## **Waterfront Construction, Inc.**

### **Cover Letter - Response to Request for Information #1 for SHL23-014 and SEP23-003 (Evers Pier Repair).**

Planning comments dated May 26, 2023 with WCI responses in red below:

PROPOSED SITE PLAN

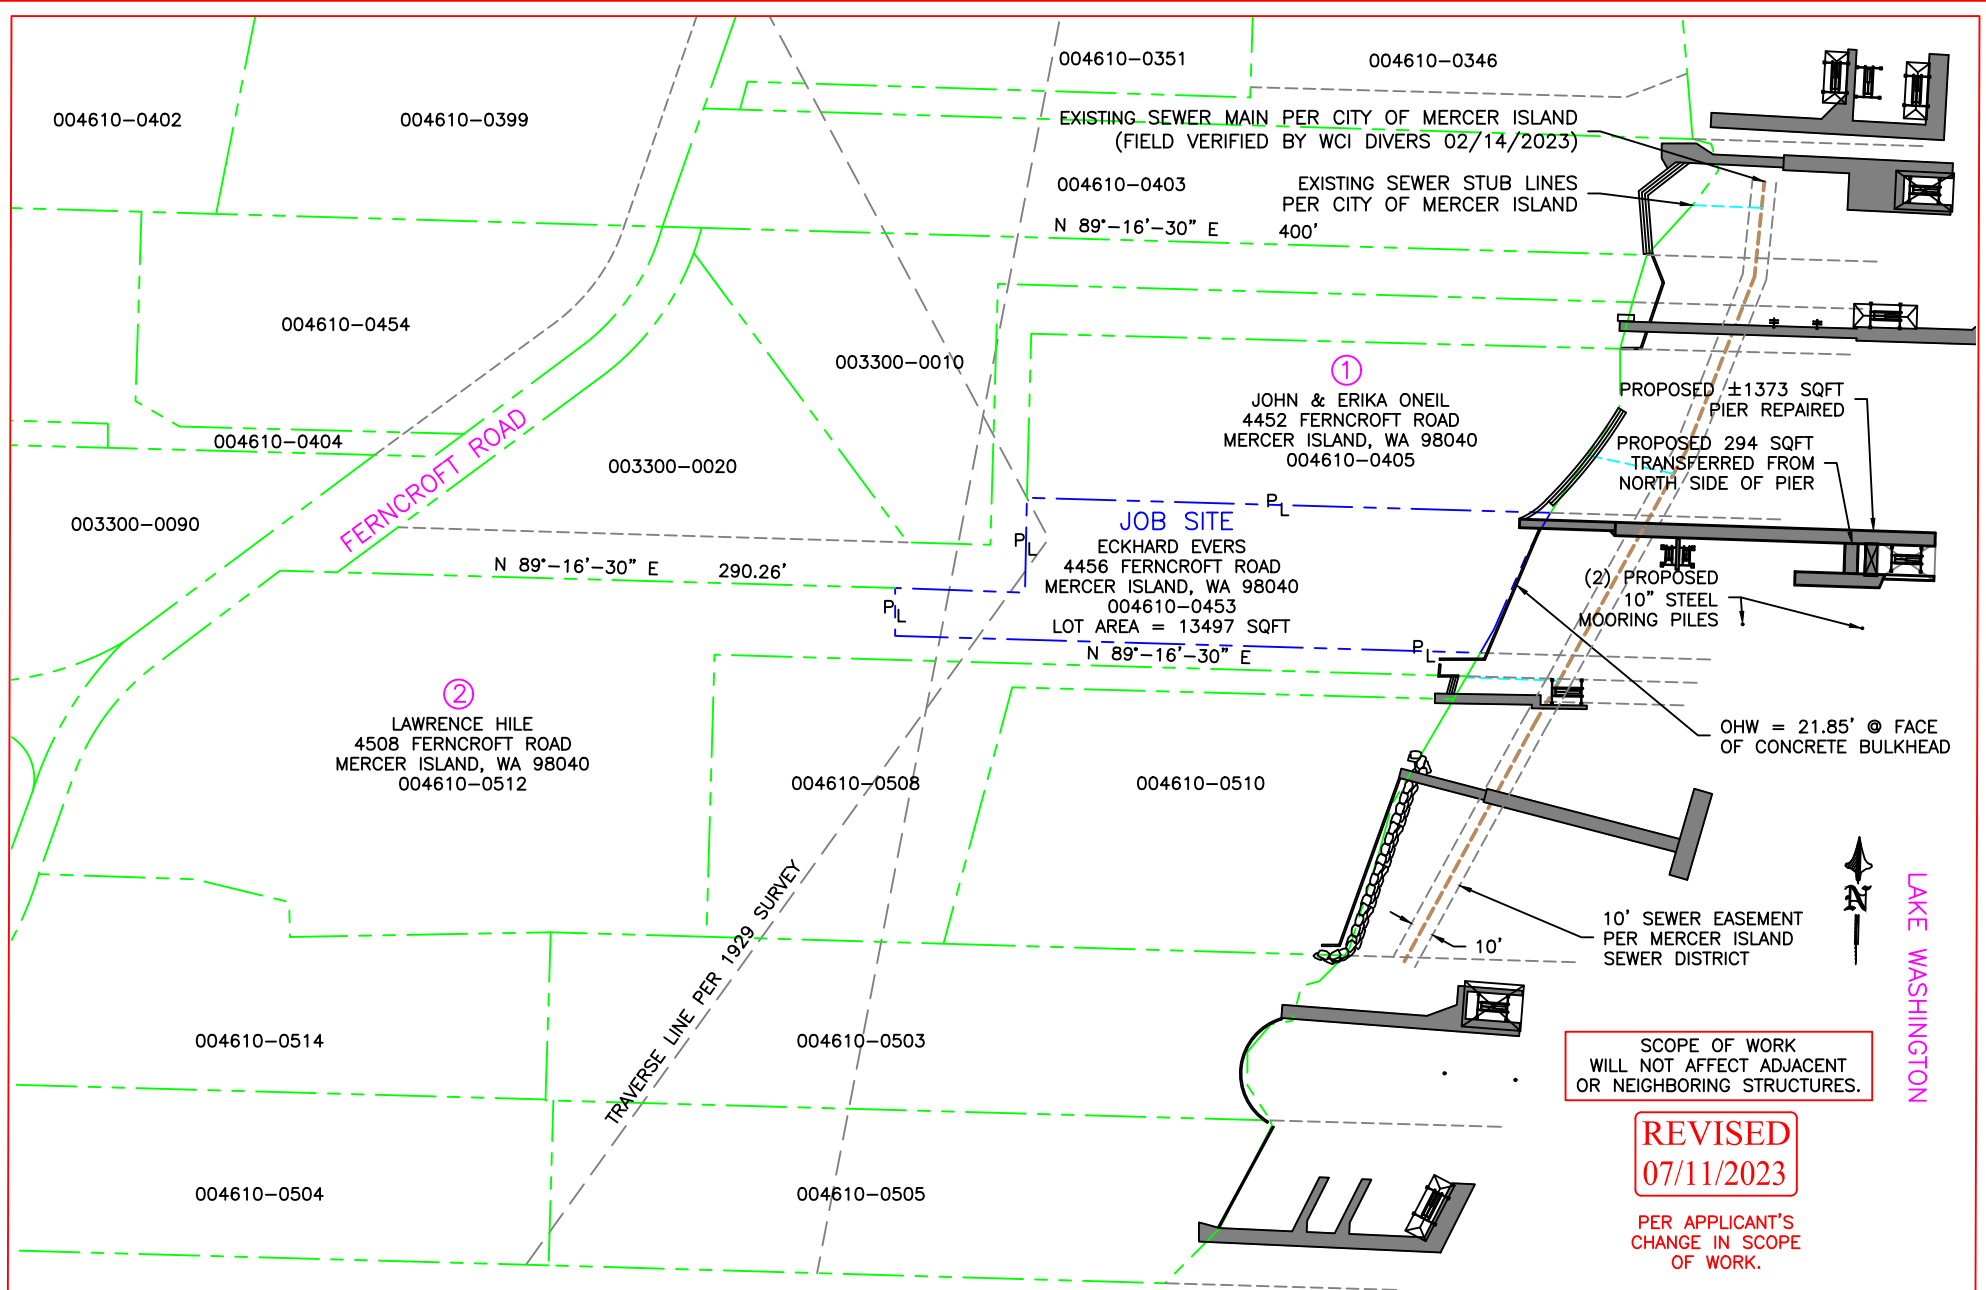
1. There is a 10-foot-wide public sewer easement in the vicinity of the sewer lake line. Please show the location and limits of the public sewer easement on all sheets of the plans.

WCI Response: 10' wide sewer easement has been illustrated on all sheets of the plan

EXISTING SITE PLAN DETAIL

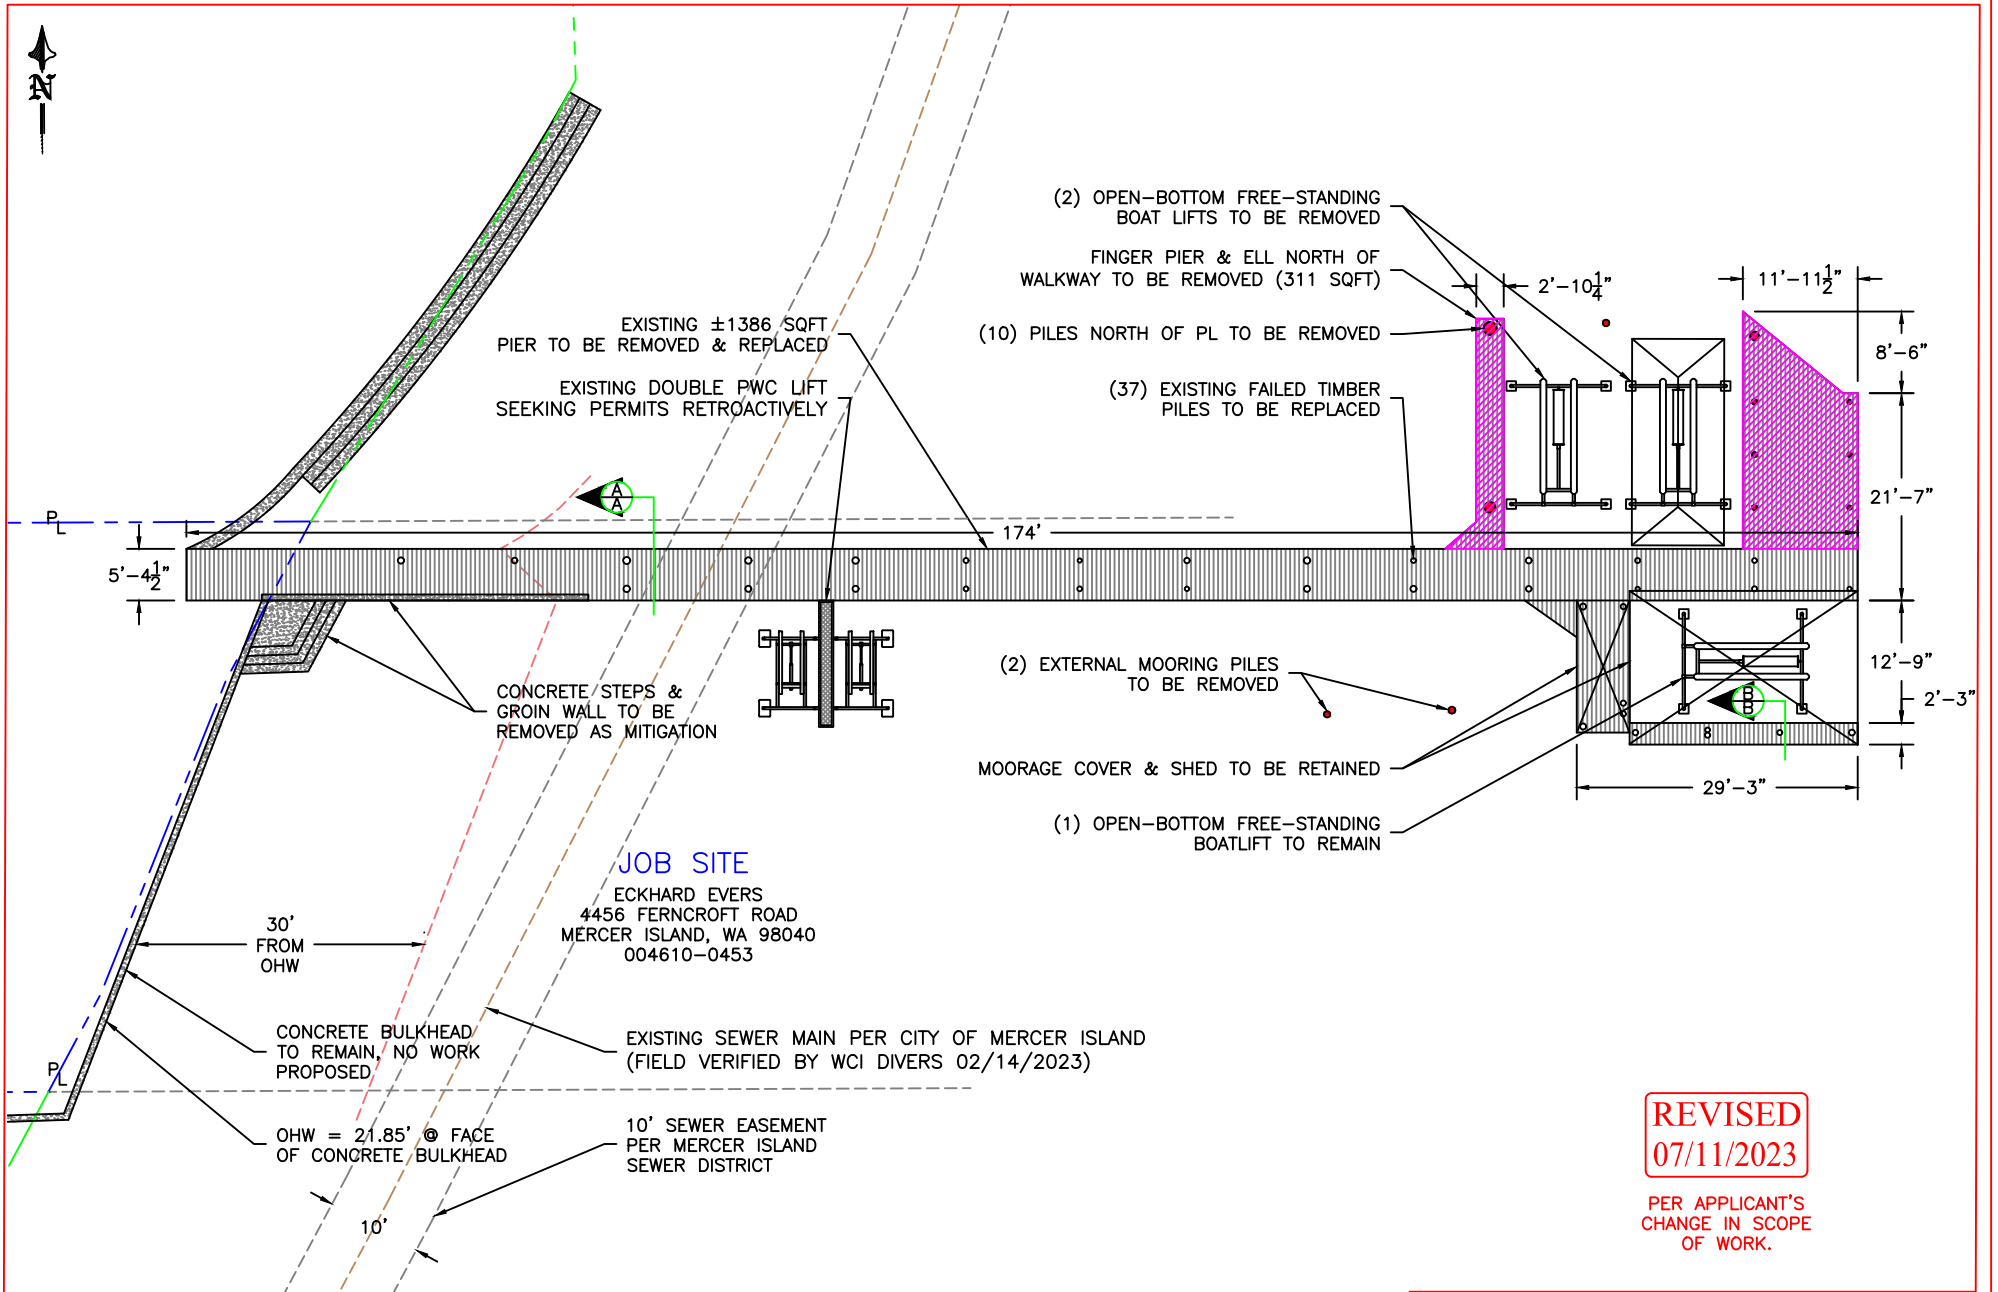
2. The site plan shows that the existing pier is located within the required 10-foot setback from the lateral line to the north and extends more than 150 feet waterward from the ordinary high water mark (OHWM). As such, the existing pier is nonconforming. MICC 19.13.020(B) states that expansions of legal nonconforming overwater structures are permitted, provided that the expanded portion of the structure is constructed in compliance with the Shoreline Master Program (SMP).

PROPOSED SITE PLAN DETAIL

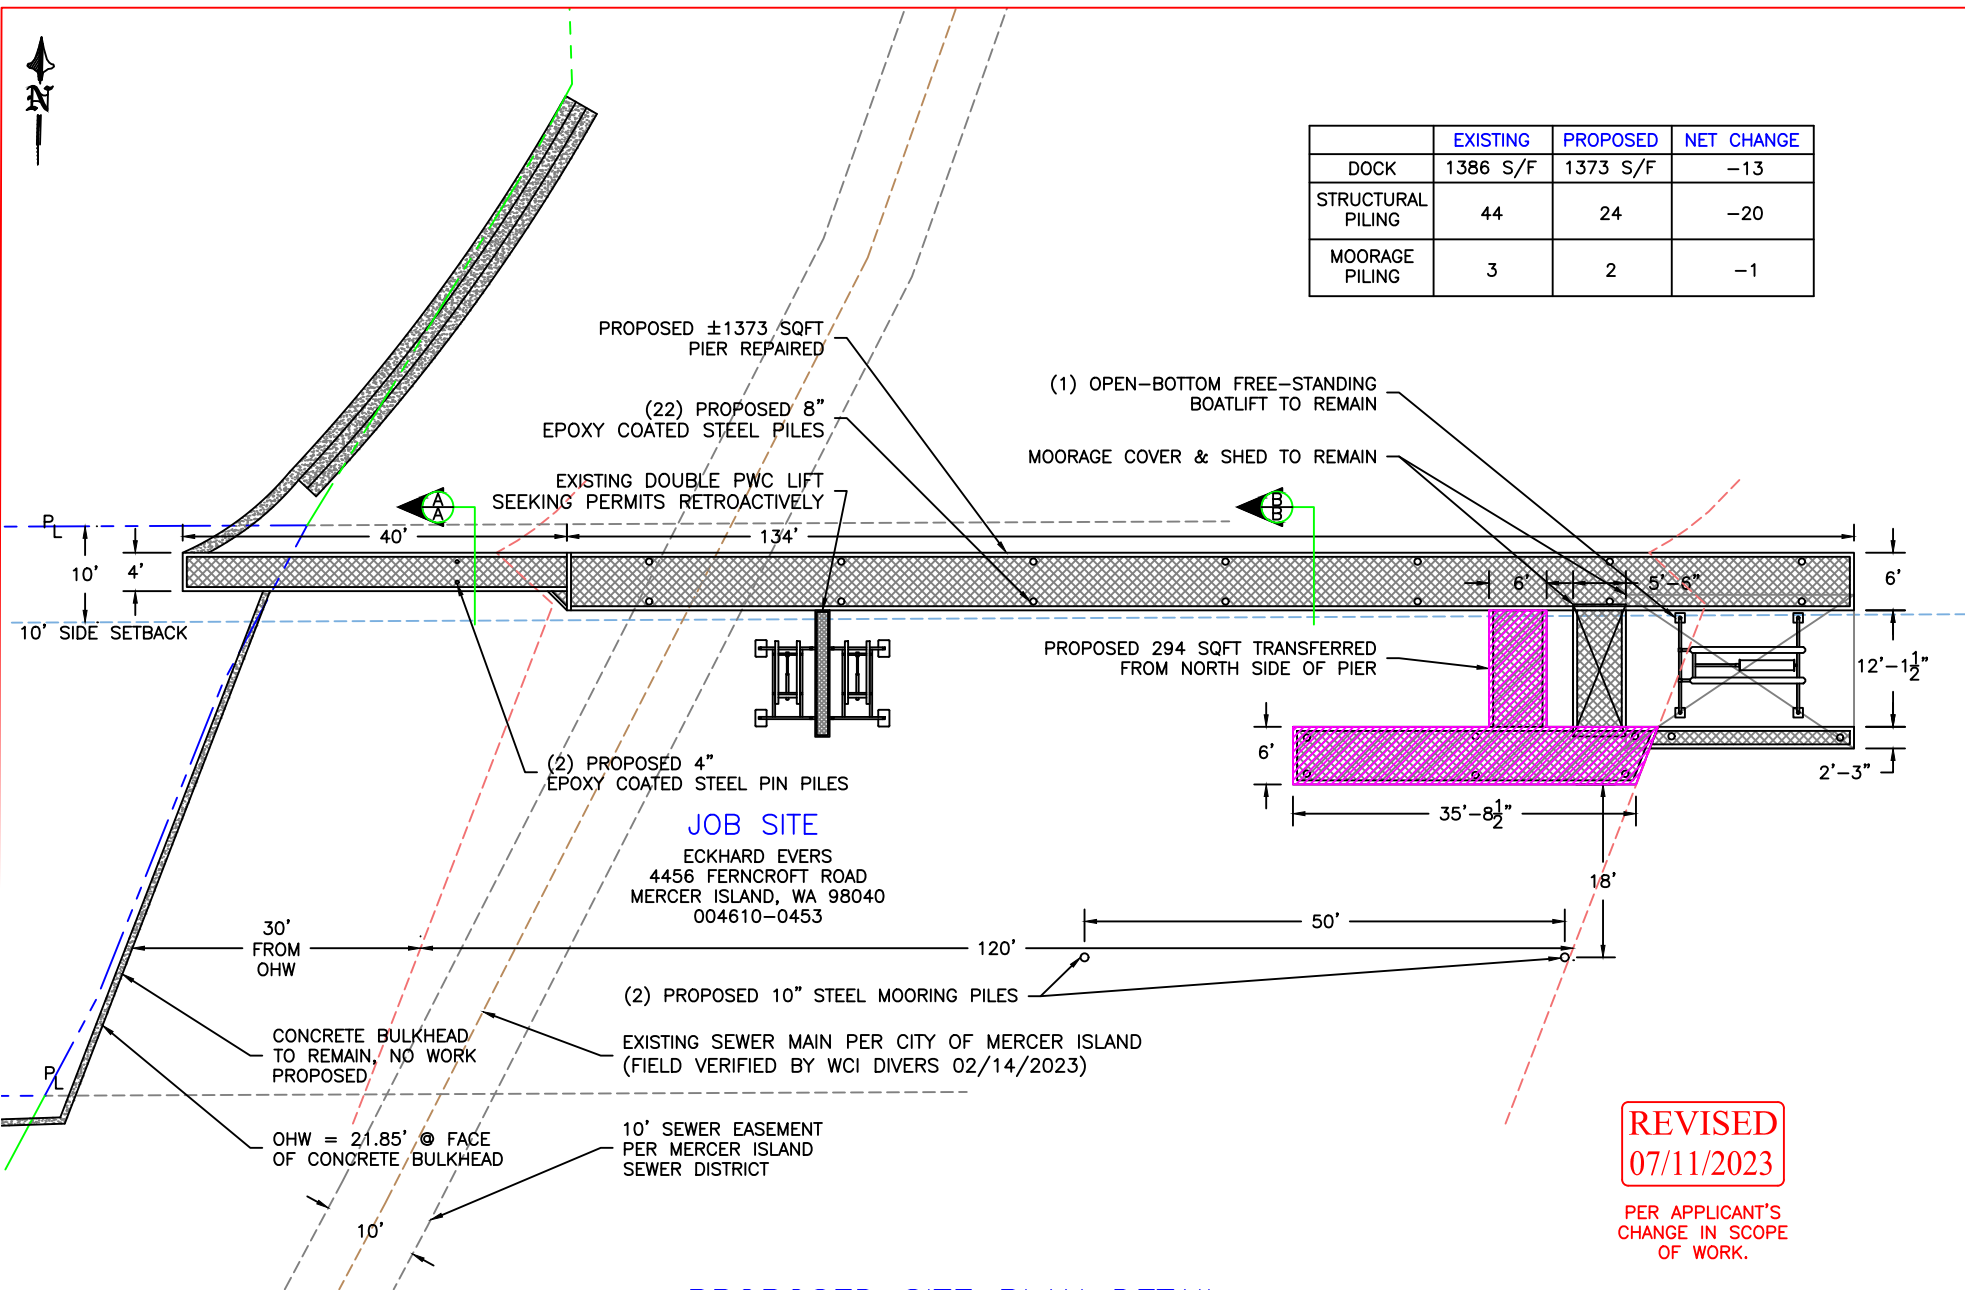
The site plan shows that a portion of the new section of pier will be located within the lateral line setback and more than 150 feet waterward of the OHWM. The site plan also shows that one of the proposed moorage piles will be located more than 150 feet waterward of the OHWM. Neither of these new elements meet the standards listed in MICC 19.13.050(D), Table D. Please either demonstrate that these elements will be constructed in compliance with the City of Mercer Island's SMP or reconfigure the pier expansion and moorage piles to meet the current lateral line and pier length standards.  
**WCI Response: The pier has been reconfigured so that no new elements will be located more than 150 feet waterward of the OHWM.**

PROPOSED ELEVATION

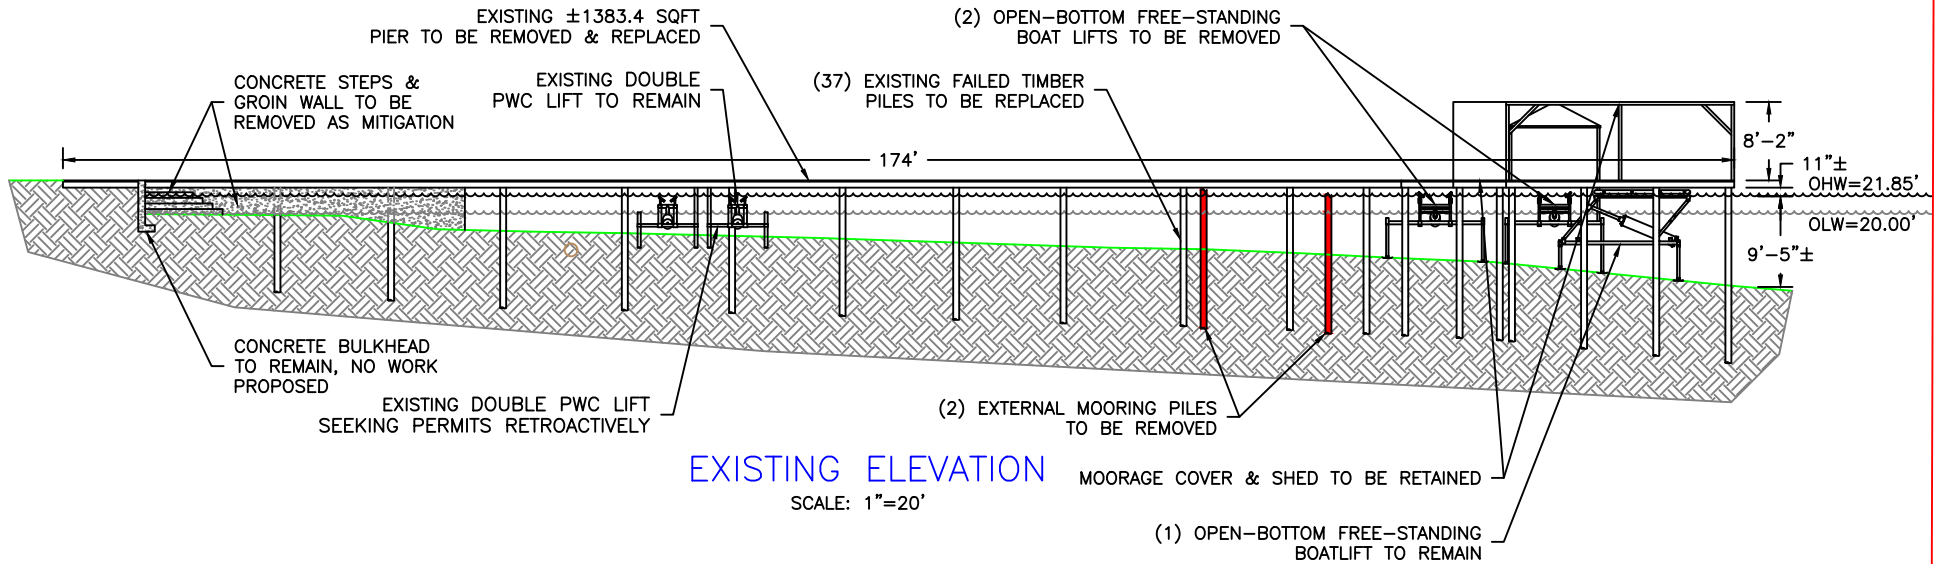
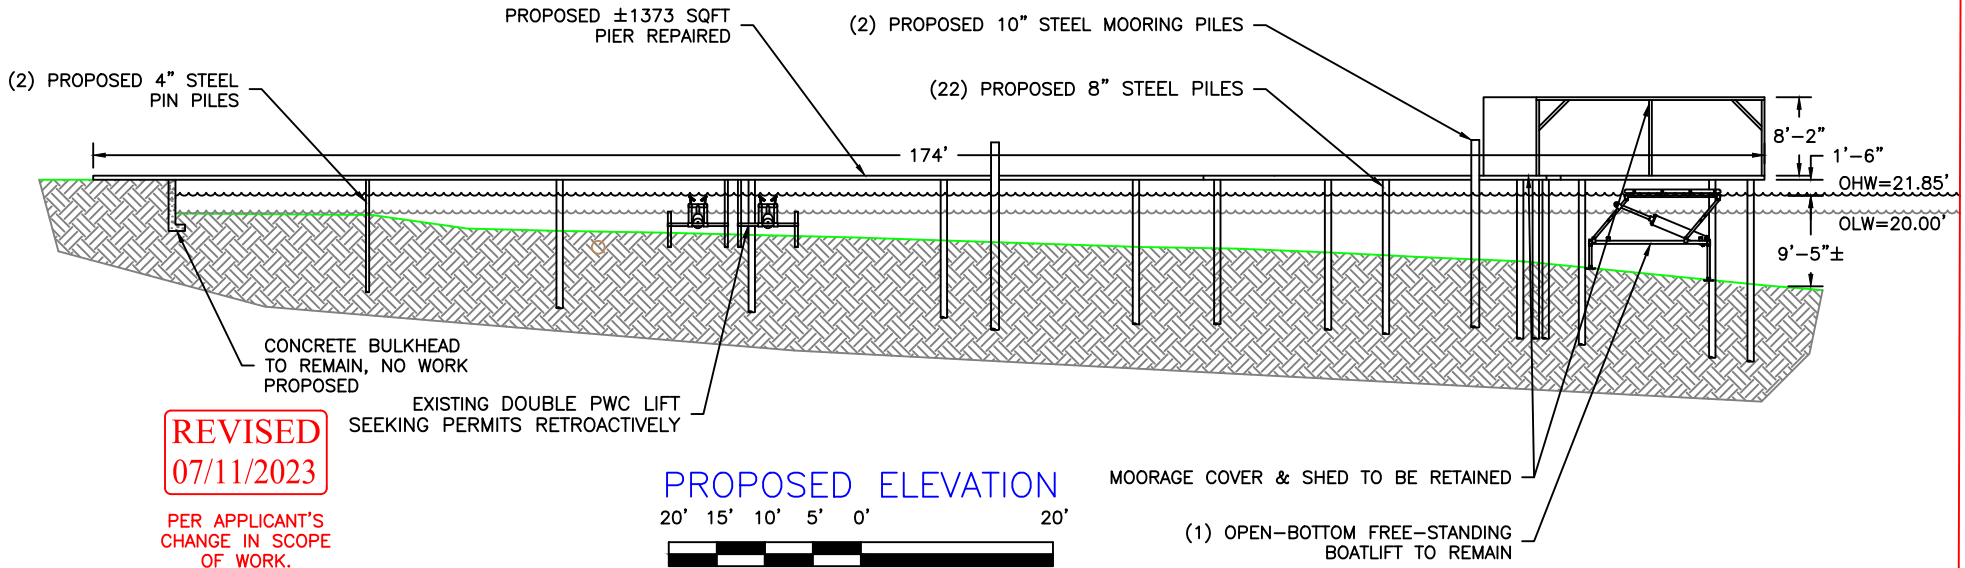
2. Please show the sewer lake line and easement on the proposed elevations in the plan set. No new pilings shall be constructed in the sewer easement.

WCI Response: The sewer lake line and easement has been showing on the elevation sheet. No new pilings are constructed in the sewer easement.
